DECISION DELEGATED TO DEVELOPMENT MANAGER

Application No: H02-1025-18 **Applicant:** Push Energy Ltd

Proposal: Proposed solar farm with associated infrastructure - approved under H02-0454-14 - various amendments to overall scheme

Location: Decoy Farm Spalding Road Crowland

Mounting System Details

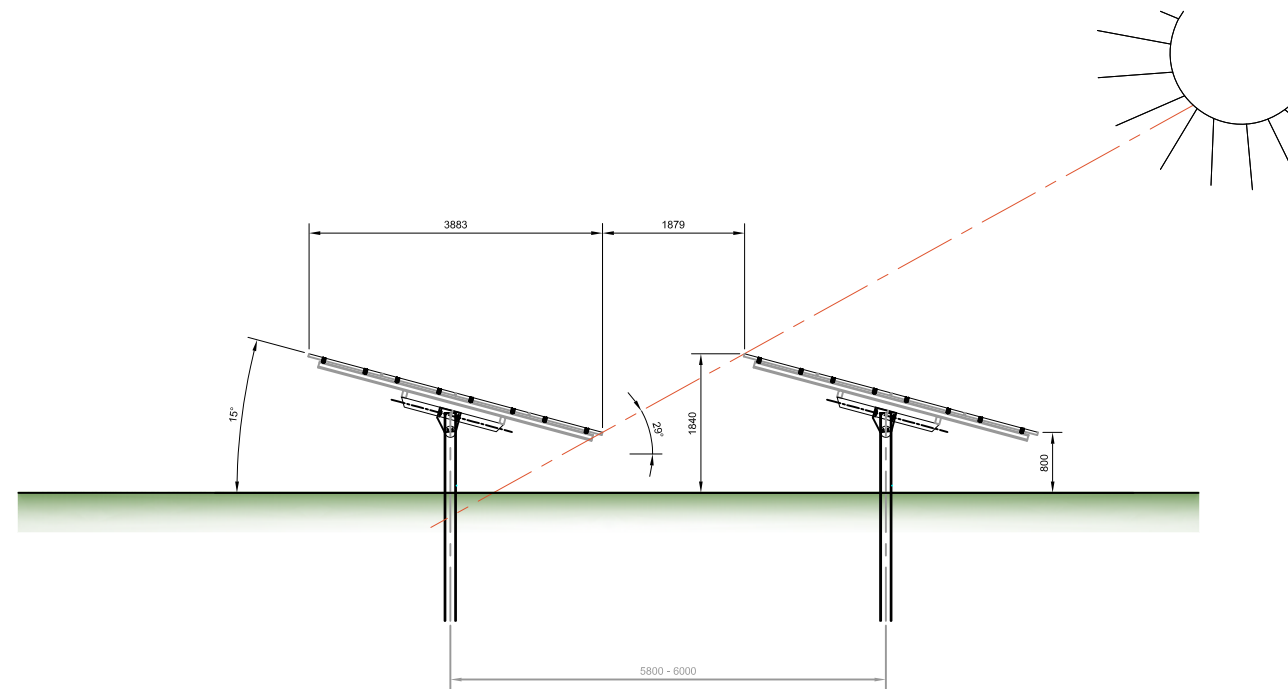
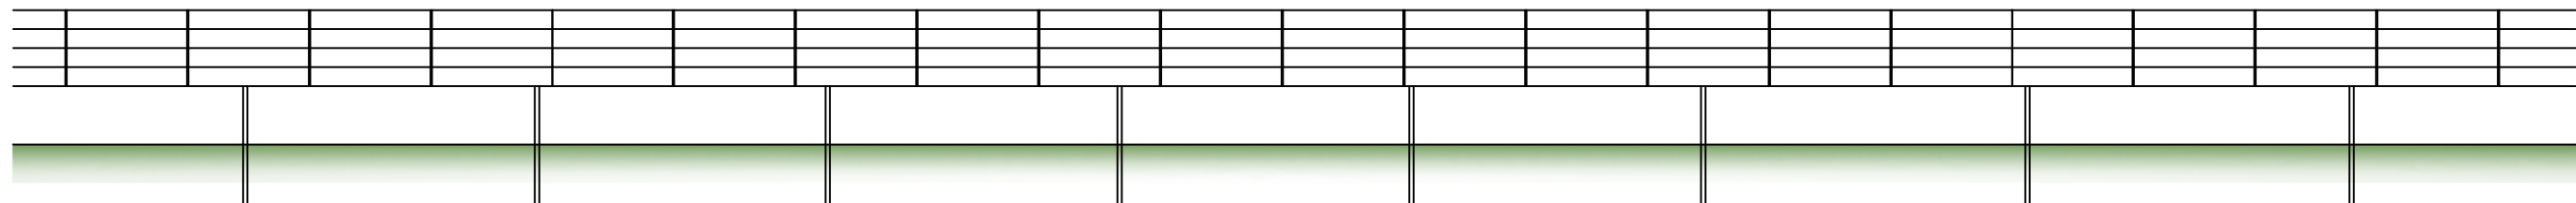
- Update drawing PA203 to include elevations of HV switchgear housing rather than the previous elevations of the Comms Cabinet;
- Revision of overflow tank location on site layout plan to ensure compliance;
- Amending elevations of Pad Mount Transformer;
- Update drawing PA010 to relocate a single door on approved Comms Cabinet; and
- Updating the mounting system plan to ensure compliance.
